RE: Submission on State Significant Infrastructure Application 6727: Barangaroo Ferry Hub and Terminal

This submission is prepared by Jones Lang LaSalle (NSW) Pty Ltd on behalf of the Building Management of Cockle Bay Wharf and Darling Park. As a key stakeholder in the Sydney CBD and Darling Harbour/Cockle Bay Wharf precincts, we welcome the opportunity to comment on the public exhibition of the Barangaroo Ferry Hub Barangaroo Ferry Terminal project.

Appendix D Indicative Wayfinding Signage Plan and Design and Indicative Opal Card Ticketing Facilities and Location

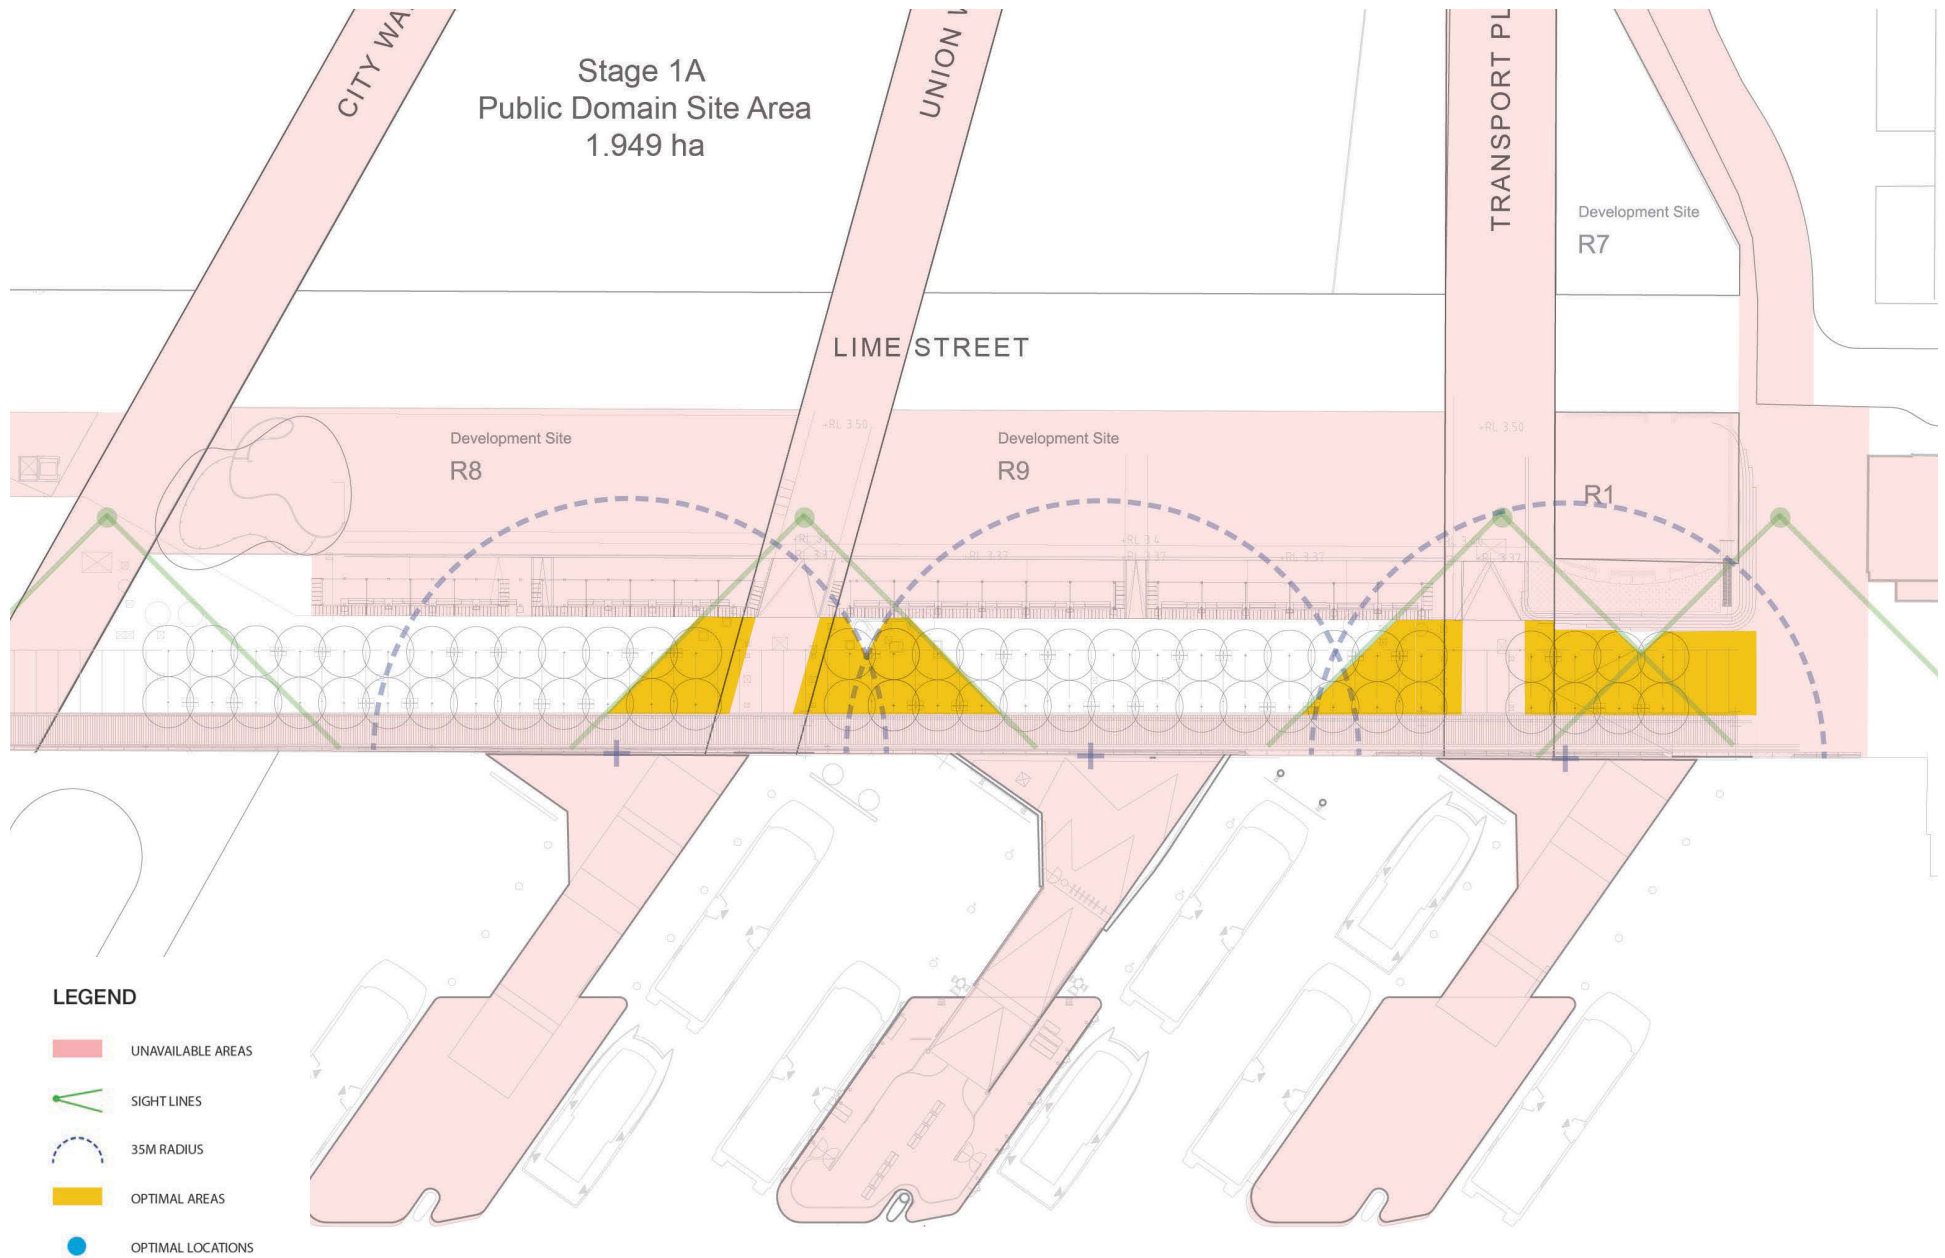
greater way-finding signage should be considered at the entrance/egress points at the Barangaroo Ferry Hub to direct visitors not only through the Barangaroo Precinct but also towards major destinations and activity hubs, such as King Street Wharf, the Sydney Aquarium and the Sydney Visitor Centre. The intent for such signage is identified on page 223 of the EIS, however is not visible within the plans for the proposal.
